GRADING & EROSION CONTROL PLANS MAYBERRY, COLORADO - FILING NO. 3

EPC STORMWATER REVIEW COMMENTS ARE SHOWN IN ORANGE BOXES WITH BLACK TEXT

GESC COVER SHEET

NO. C8.0

C8.2

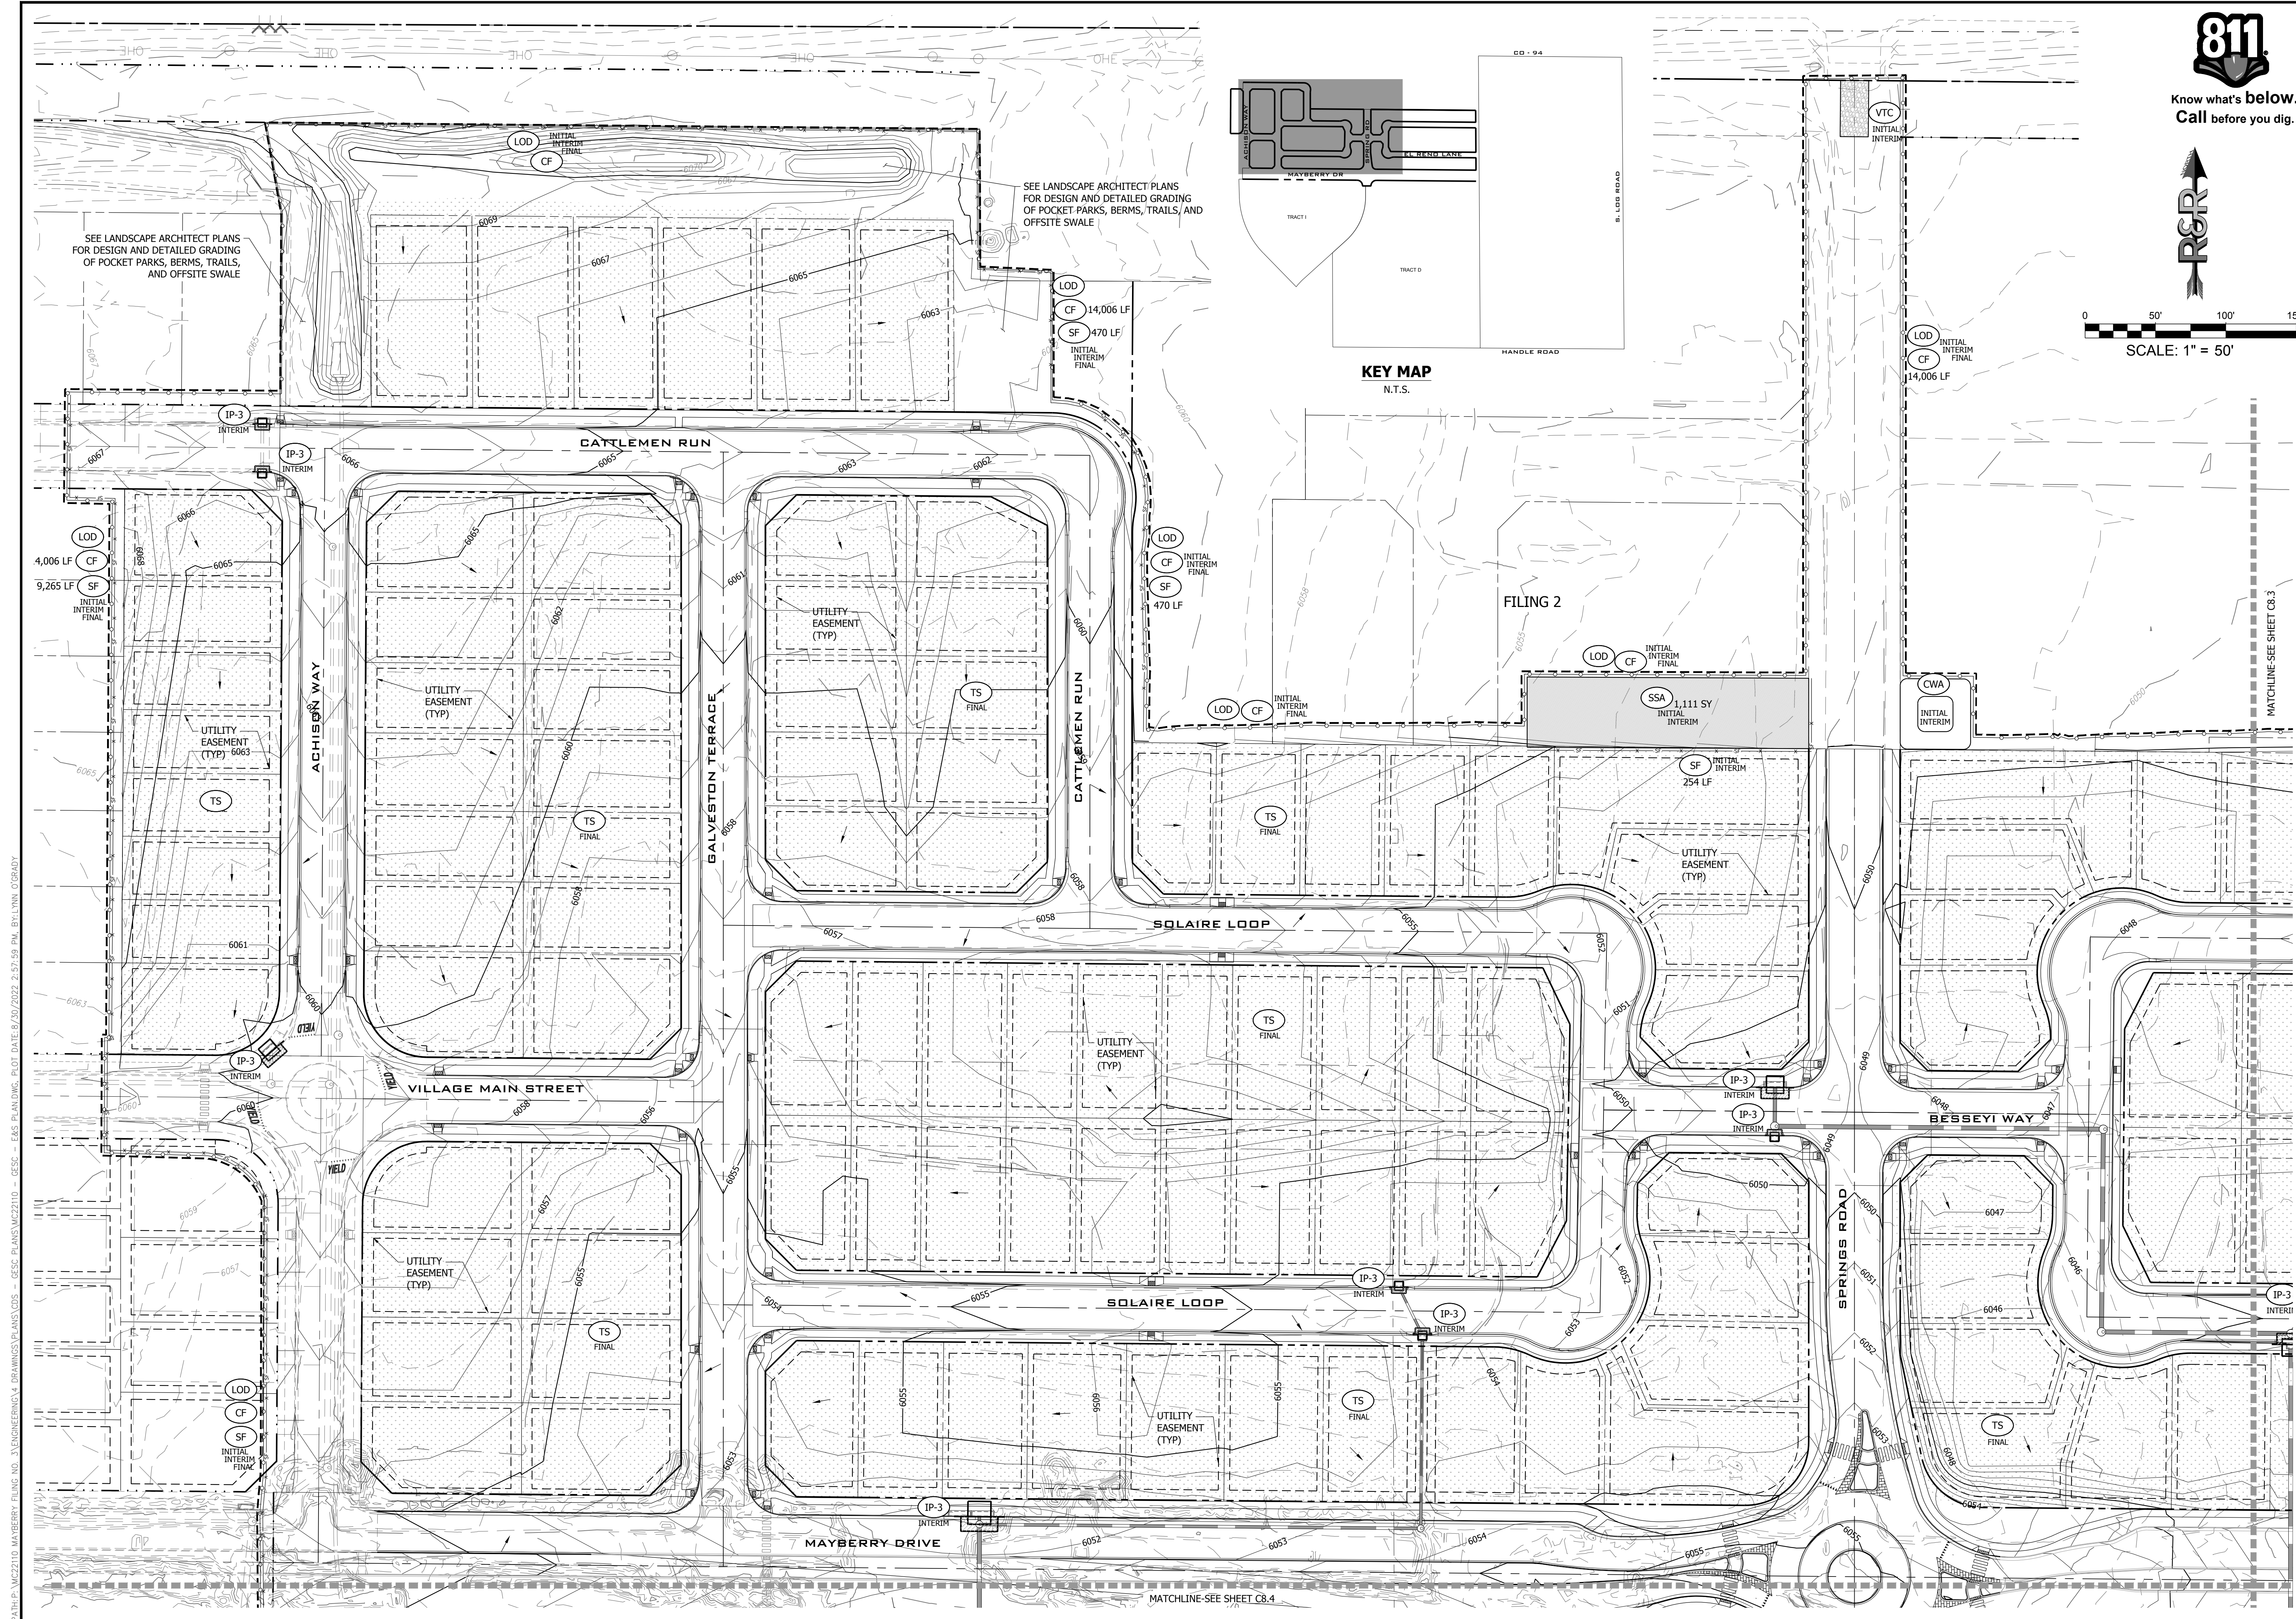
Are these rock check dams or straw bales?
 Straw bales are only suitable for minor drainage ways, not major. We have been seeing a lot of blow outs when using straw bales in ditches after a large rain event. Consider using straw wattles (3 stacked like a pyramid) or rock checks in lieu of straw bales.

Show calcs in drainage report to determine if outlet protection is necessary and that the SW will follow this bend

provide a separate maintenance agreement and O&M for the sodded grass required at this channel. Concern is the maintenance and keeping the sod alive

you do not need SF along ditch.

limit ECB to ditch
 adjust CD alignment

label trail and material
 and provide detail
